The reference numbers used are from the document ExQ2

4.1 the applicant recites the Holford rule 3 - where possible choose inconspicuous locations for angle towers, terminal towers and sealing end compounds. Options 1 and 2 put forward both do this but option 2 is more compliant than option 1. It is agreed that option 2 has 2 more angle towers than the NG proposal however one of them is in the sealing end compound and the other one is only a very slight angle. Both of which are in inconspicuous locations and only really seen by the landowner. The decision to proceed with their proposal is as already stated an economic one which NG as pointed out at the hearing are bound to take but the economic effect on the landowner must have some effect on the decision making process.

Plan View 3
Low Loaders passing
Scale 1:200

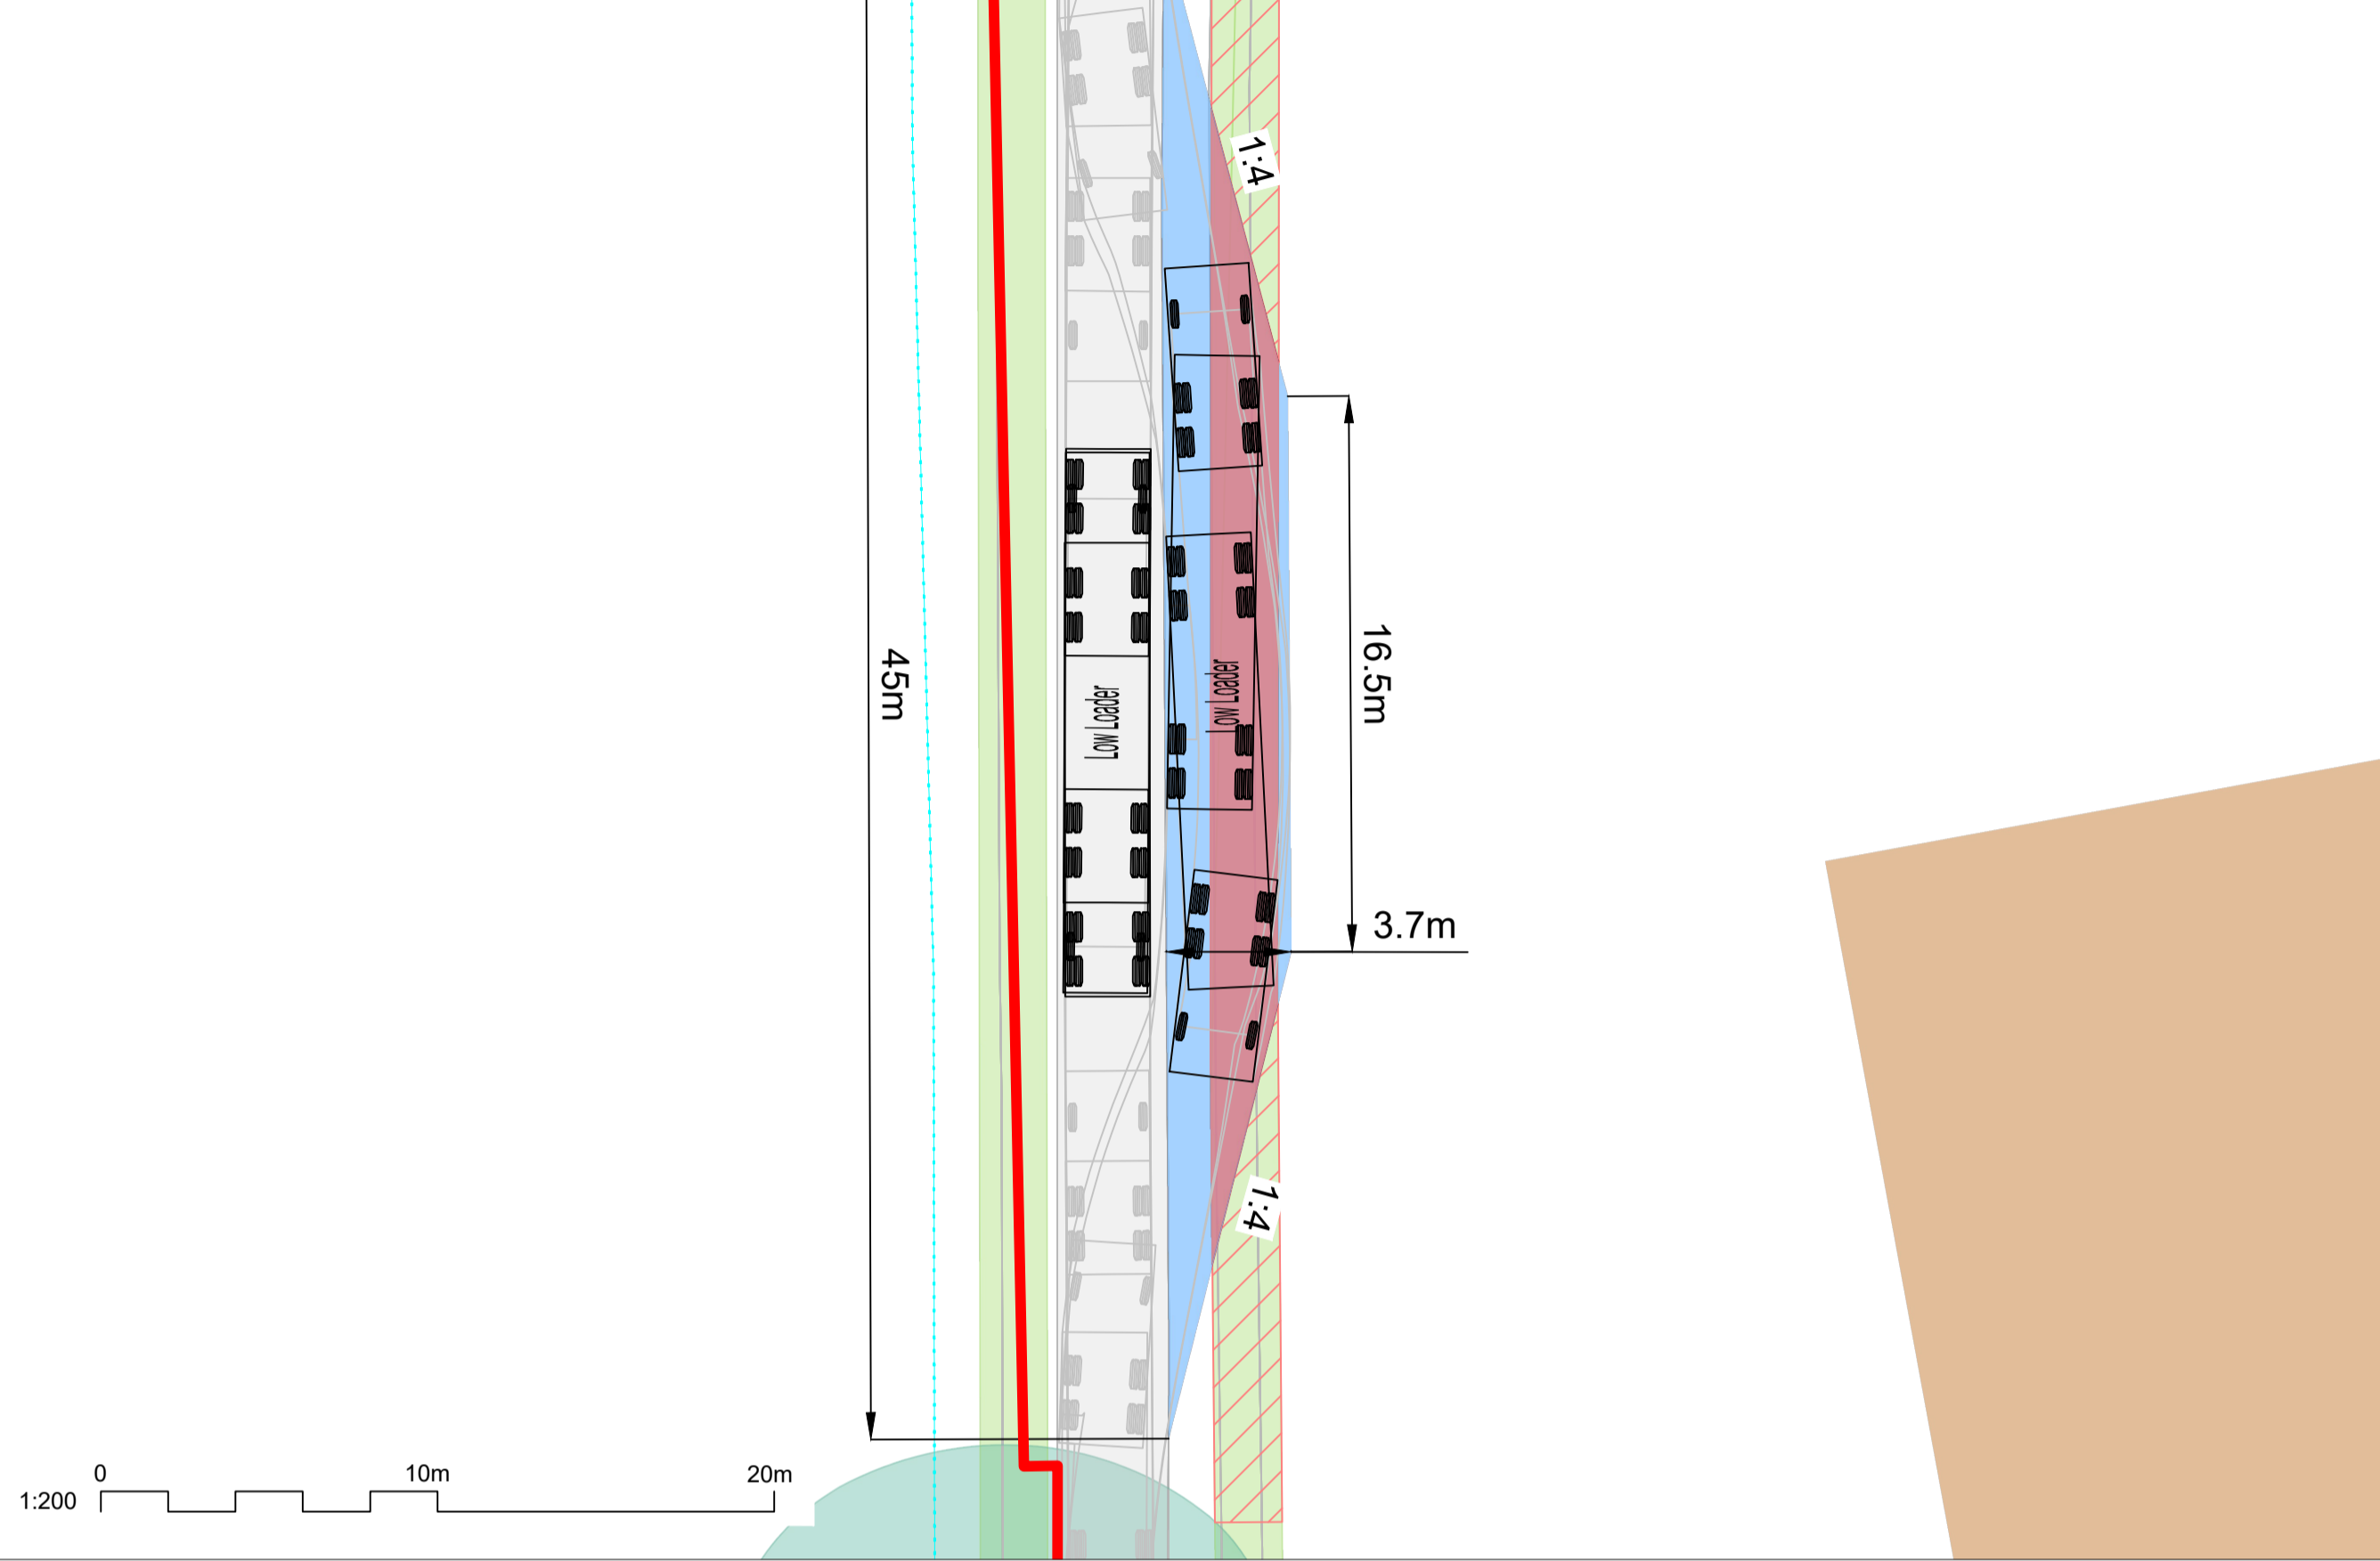
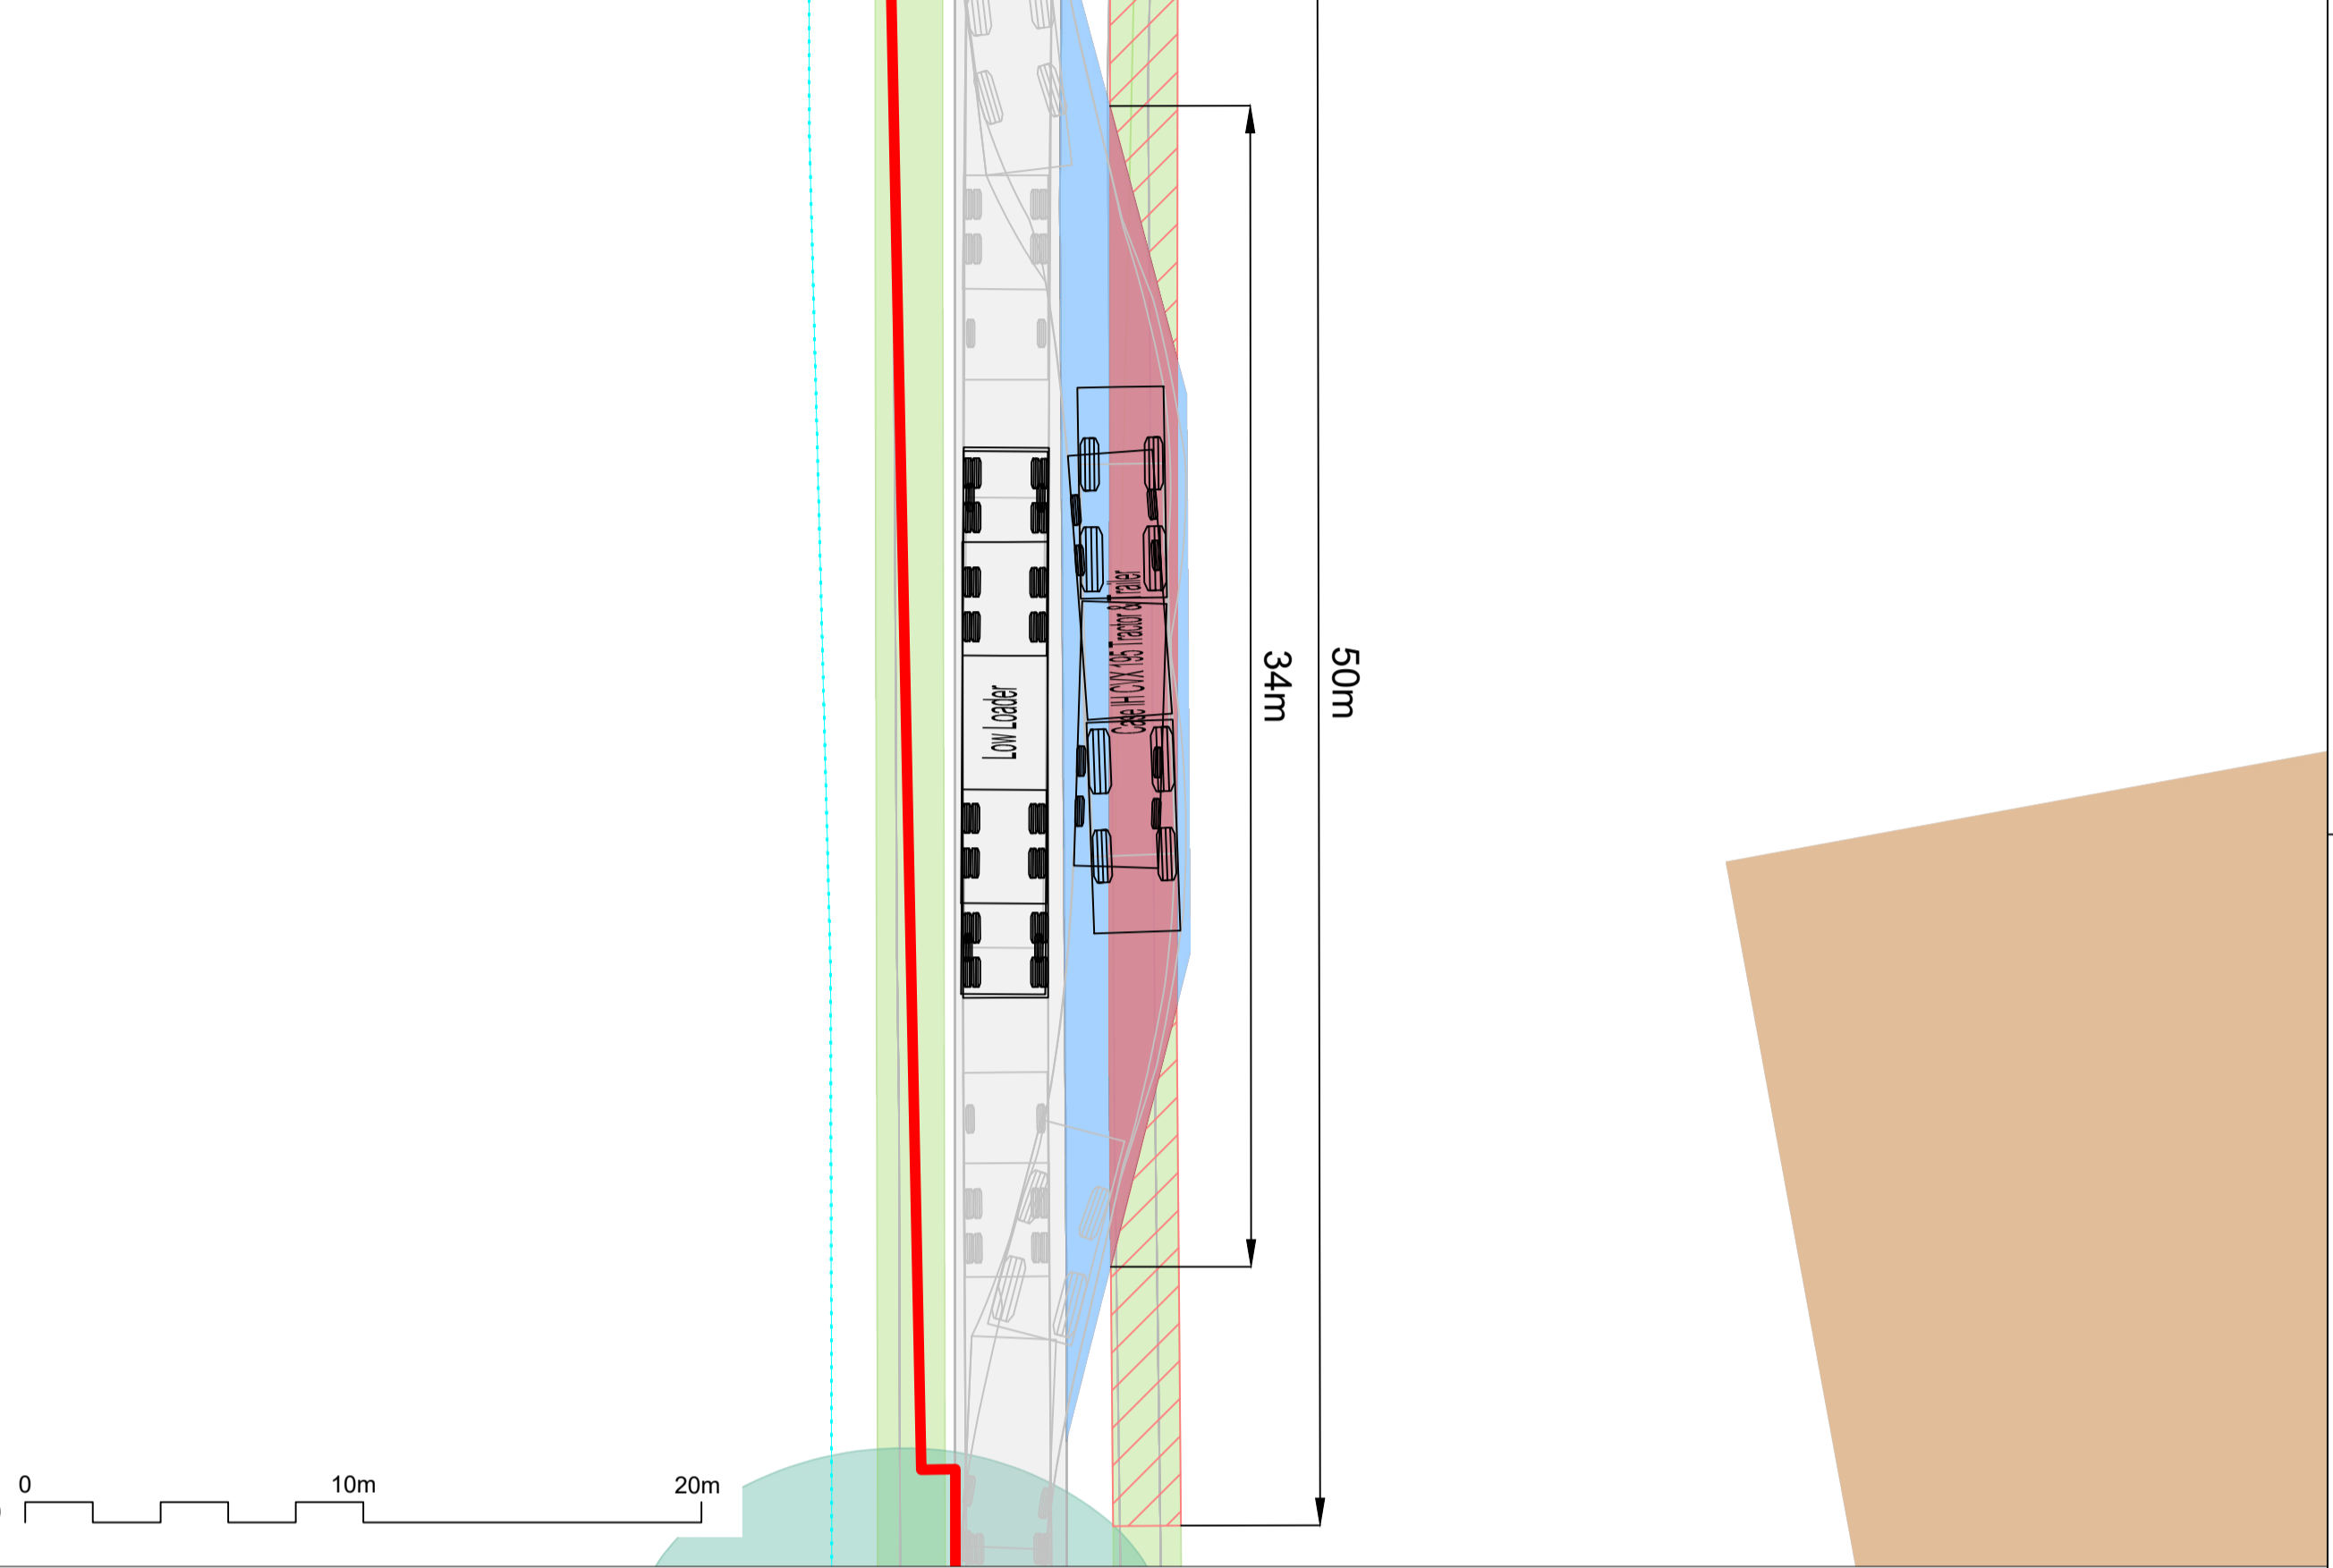
discussions are on going between the parties in the light of the proposed change to the permanent access route to the sealing end compounds. However the proposed location of the 2 passing places on Newlands Lane was received from NG last week - this propose to remove in total 100m of strong mature thorn hedge which is circa 7-8 feet tall, there has been no proposal put forward as to how the construction traffic will be managed. On boundary between the 2 compounds there is a dead oak tree and with some crown pruning an gap can be made in this location to allow construction traffic to pass unhindered and safely through to the sealing end compounds. This is a matter for further discussion with NG.
